**From:** Sam Stonehouse  
**Sent:** Tue, 7 Dec 2021 15:16:03 +0000  
**To:** Burlow, Alexa  
**Subject:** RE: DC/21/2245/FUL - Rathkeltair Lodge, Barton Hill, Fornhan St Martin

**From:** Burlow, Alexa <[alexa.burlow@westsuffolk.gov.uk](mailto:alexa.burlow@westsuffolk.gov.uk)>  
**Sent:** 26 November 2021 10:46  
**To:** Sam Stonehouse <[sam@evolution-planning.co.uk](mailto:sam@evolution-planning.co.uk)>  
**Subject:** DC/21/2245/FUL - Rathkeltair Lodge, Barton Hill, Fornhan St Martin

781-1 007

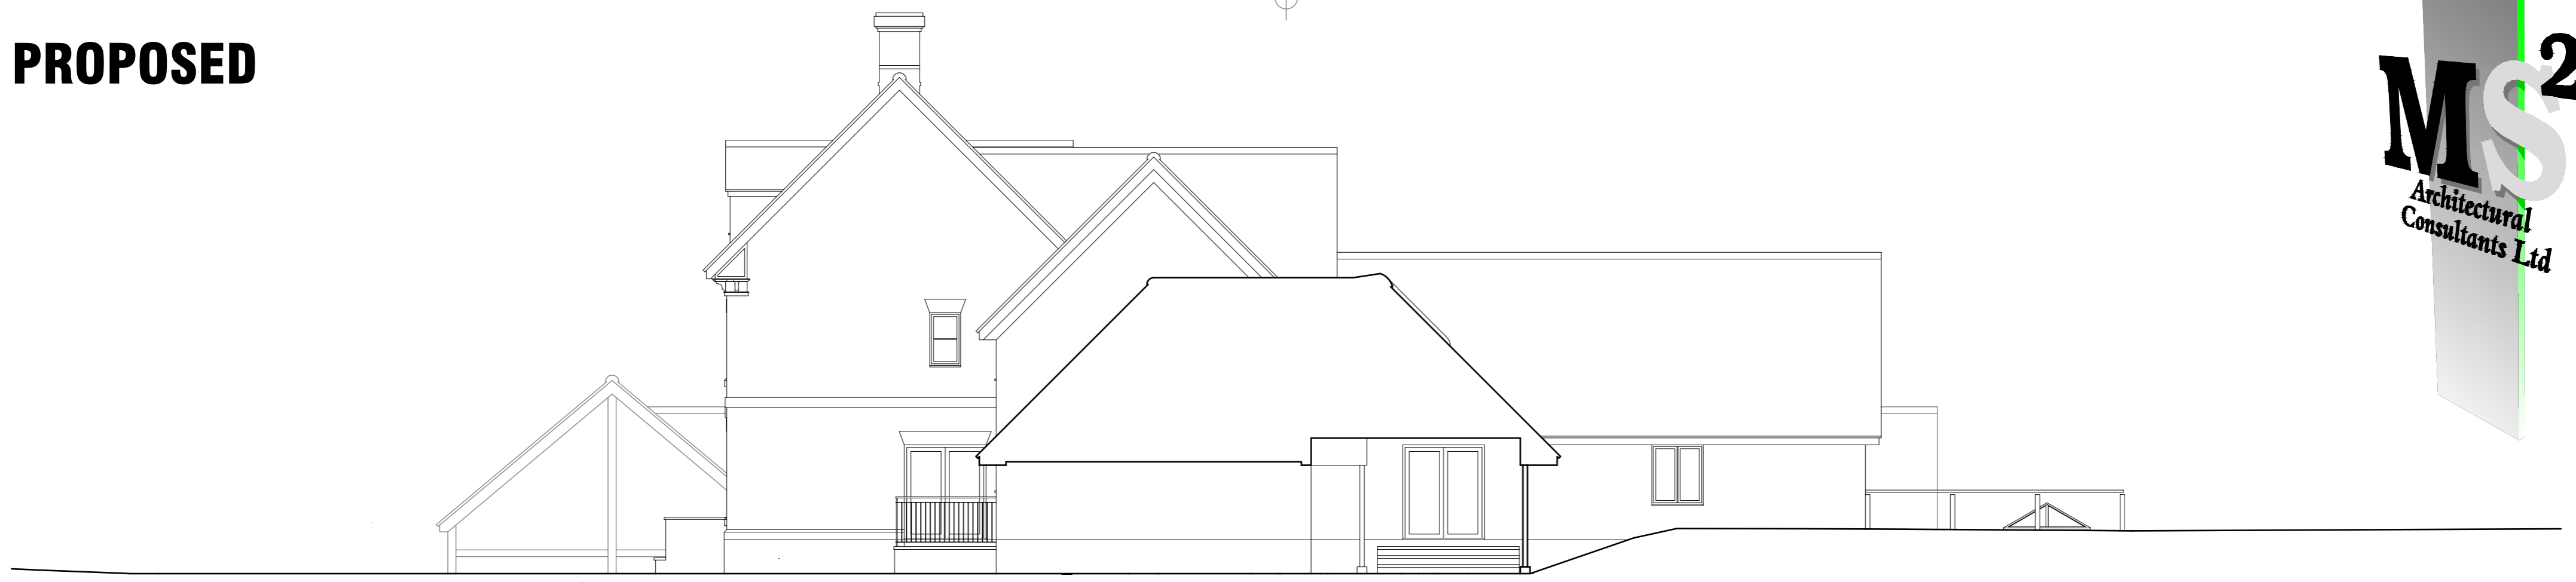
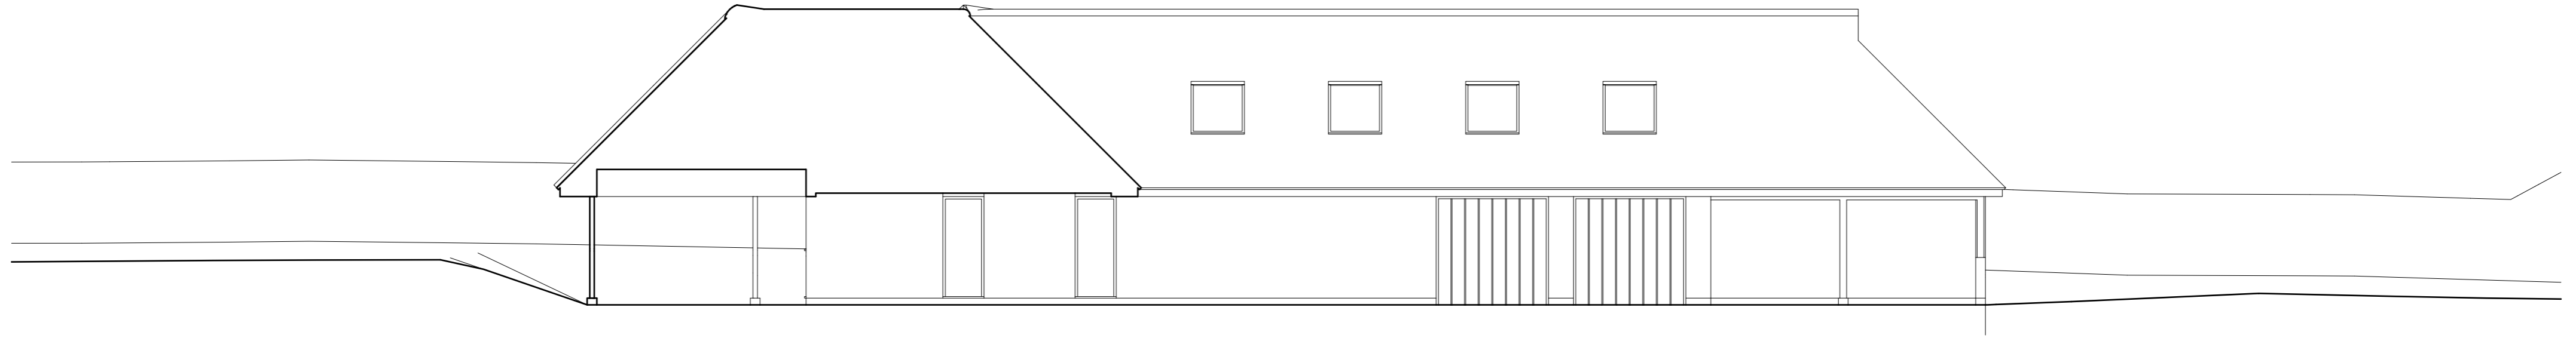
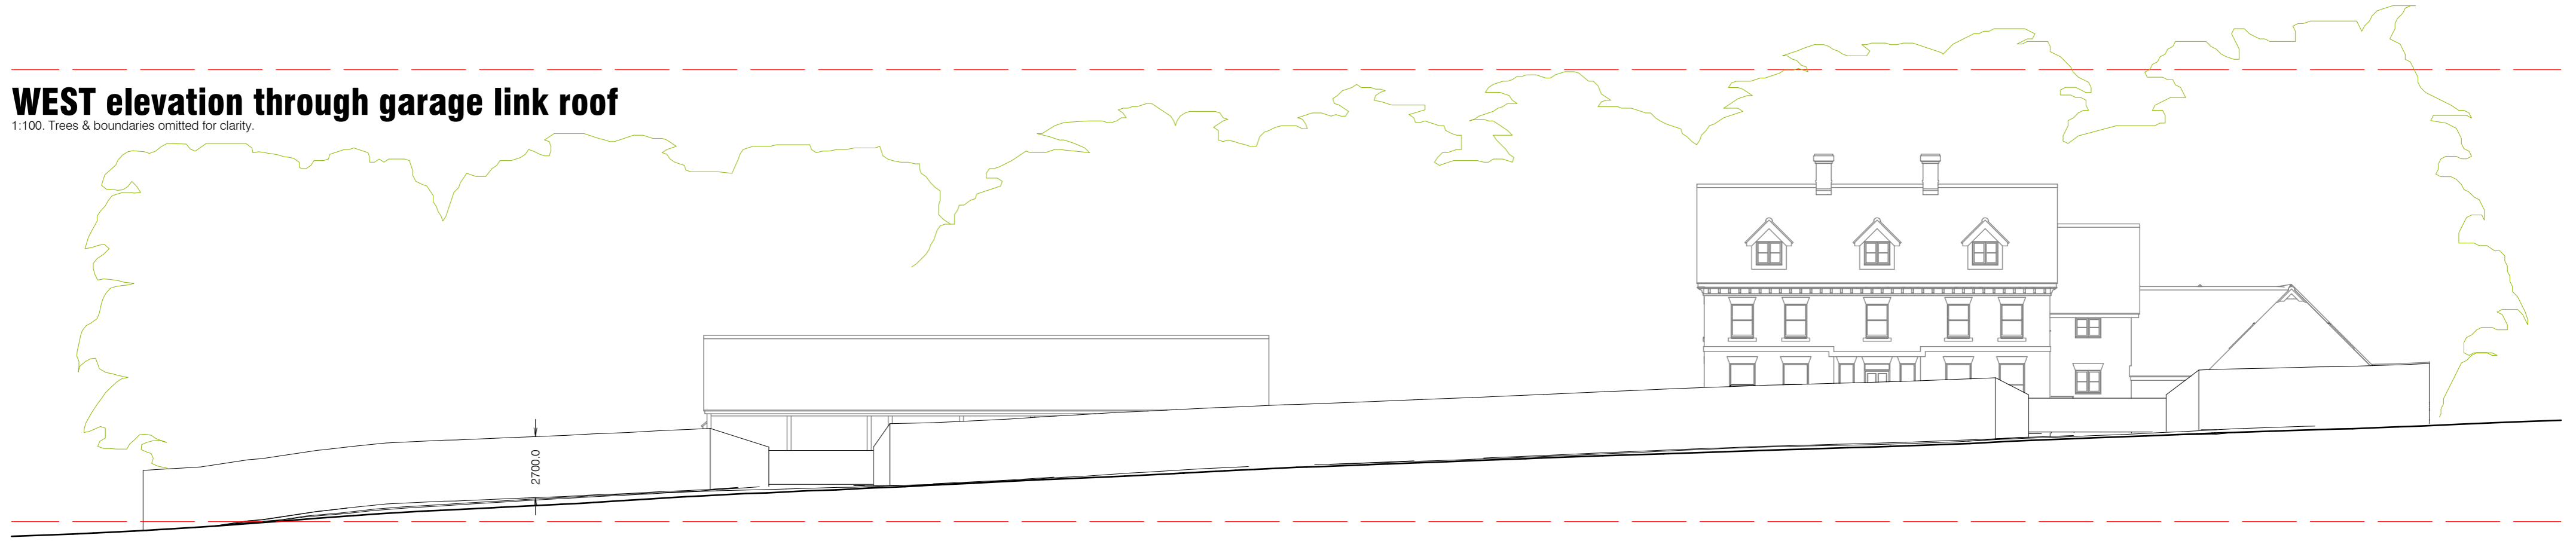
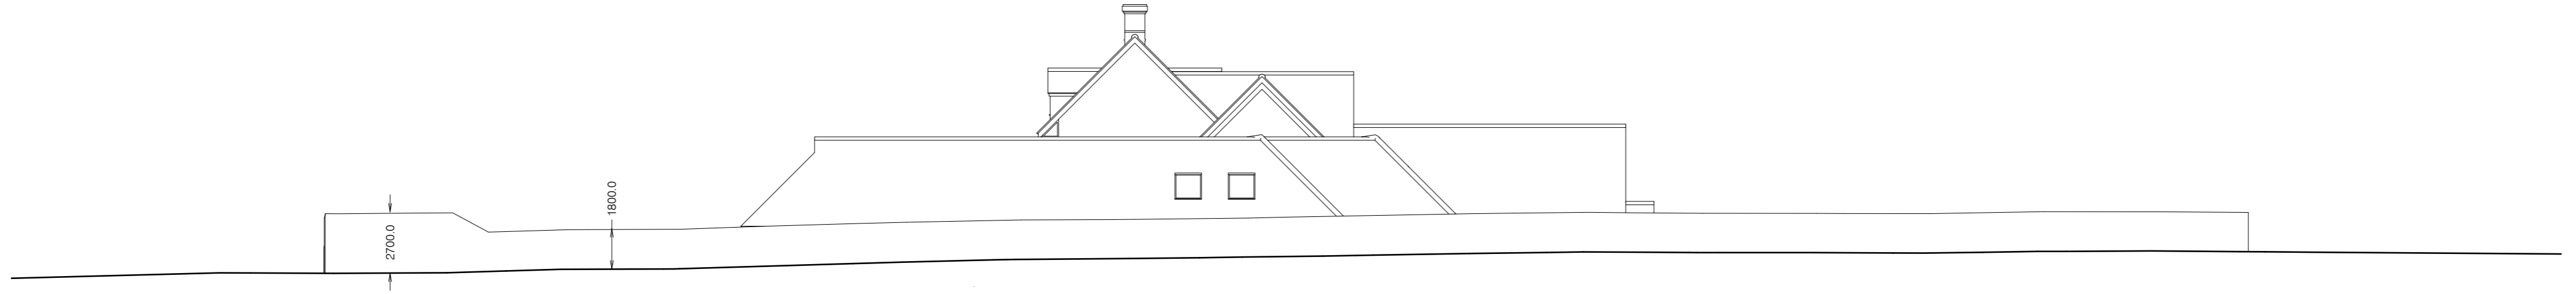
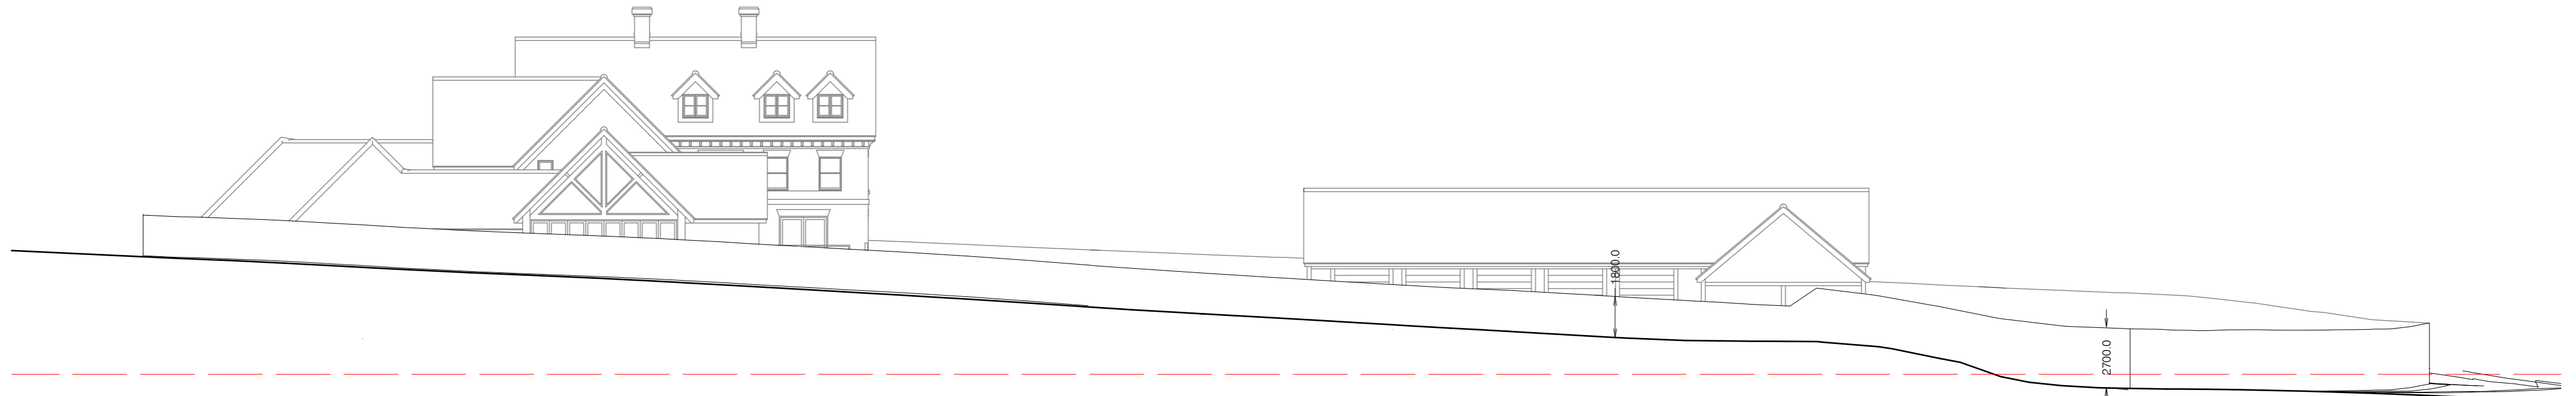
Thank you for your email and amendments. You have not mentioned if there are new gates at both accesses and they aren't shown on drawing 007, can you please confirm if they are new gates if so please provide drawings of the proposed gates.

- Can you please supply a proposed section of the north elevation of the dwelling, to show it without the garage as well. *Please see updated submitted elevations Plan 781-1b-007*

Can you please supply a proposed section of the north elevation of the dwelling, to show it without the garage as well.

I have just spoken to the architect who has confirmed that there are no gates over the accesses.

- The proposed block plan it looks as you are proposing a 2.7m close boarded acoustic fence to the south, west and north boundaries, as well as gates at both the accesses – if they are not already in place that will require planning permission. We will need proposed elevations of this and it should be included in any of your supporting documents i.e. Design and Access Statement or Planning Statement. If it is all in place at the moment, please amend the block plan to label it as existing. *I have updated the title of the planning statement and covering letter to include a fence. Please add this to the description of the development also. The fence elevations are shown on submitted plan 781-1b-007.*

WEST elevation

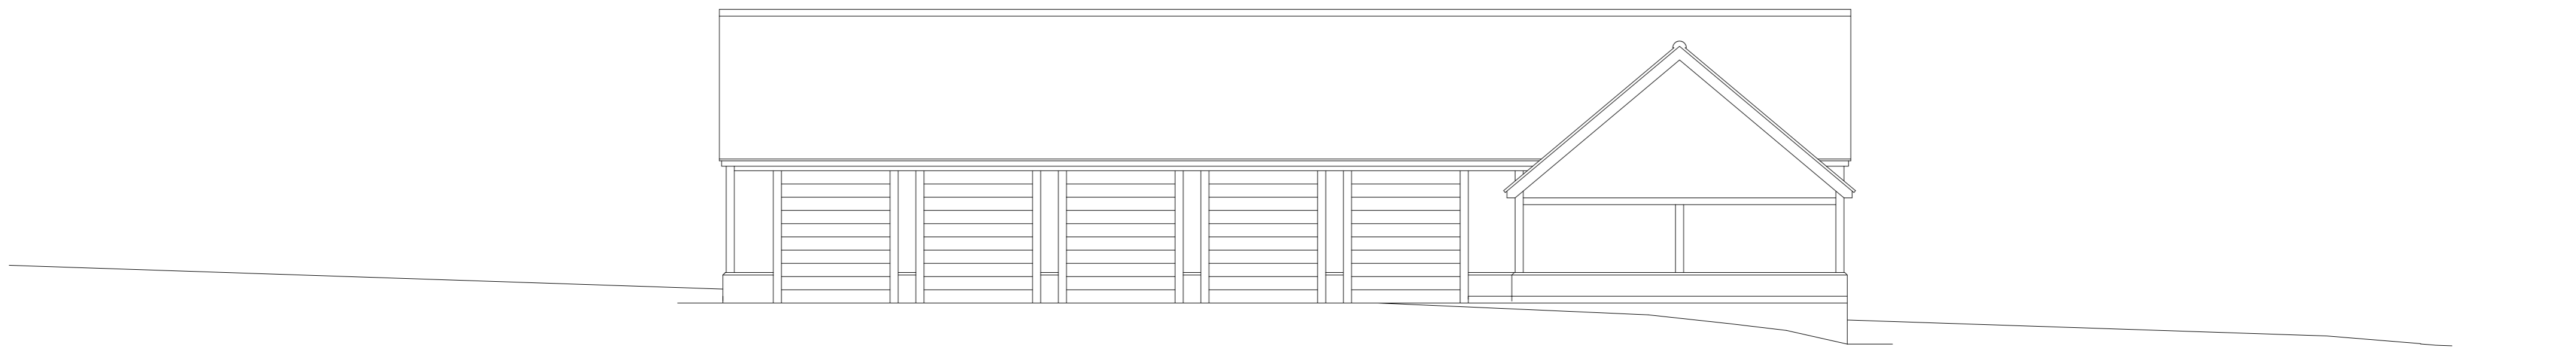
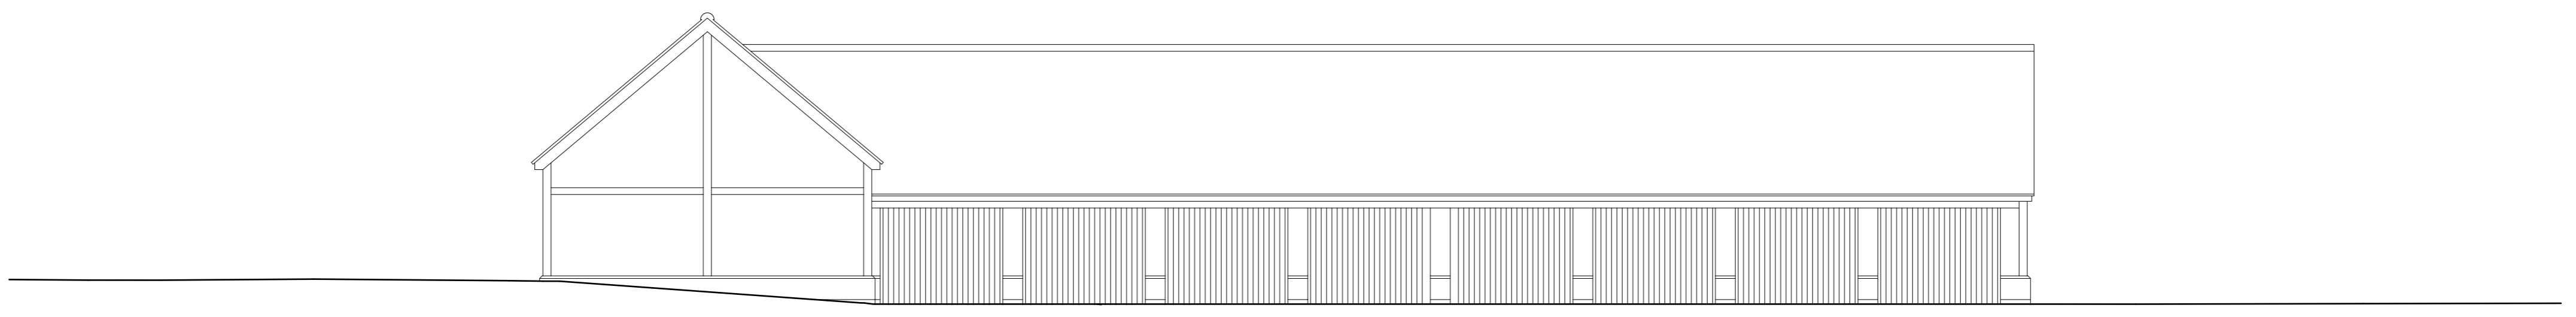
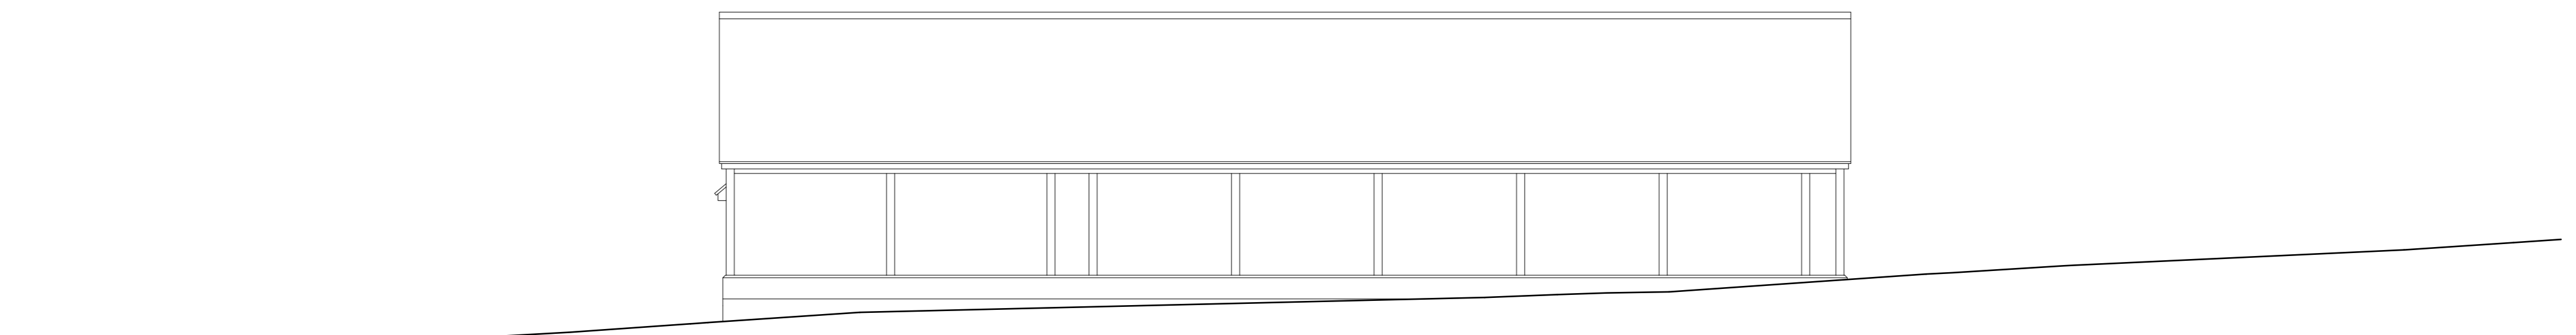
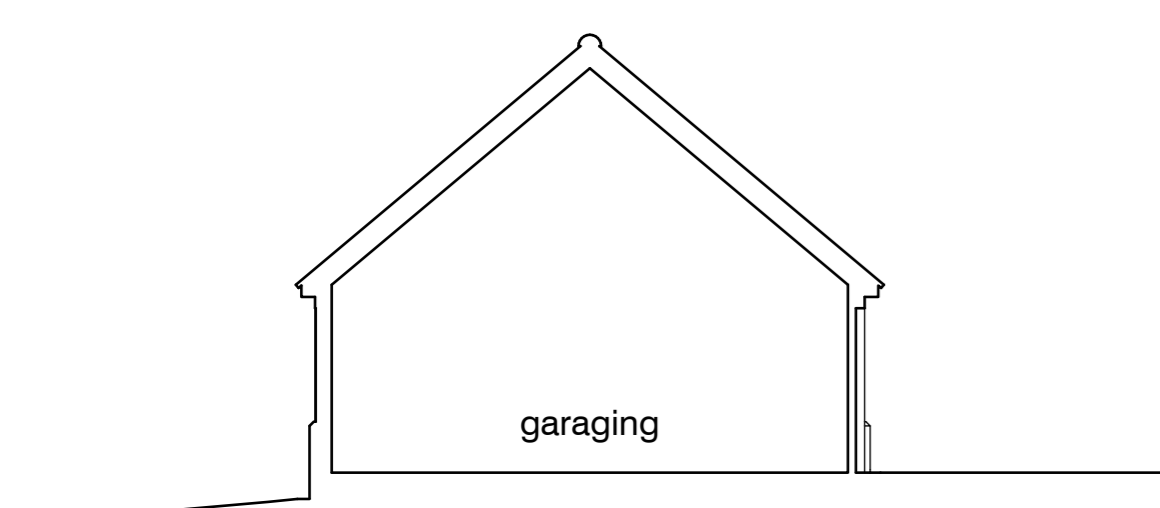
- Please provide a proposed floor plan of the mezzanine floor to the proposed garage block. *Please see updated plan 781-1b-003B.*
- The window to the boot room on the ground floor is missing off the East elevation. The east elevation shows roof lights in the first floor above the garage/workshop/store but not on the floor plans. Please amend accordingly. *Please see updated plan 781-1b-005A*

- The doors to the gym measures 1.7 metres on the west elevation, it does not match the floor plan measurements which is 4.2 metres, please amend accordingly. *As discussed this window is behind the step. Additional view has been added to help clarify to plan 781-1b-005A*
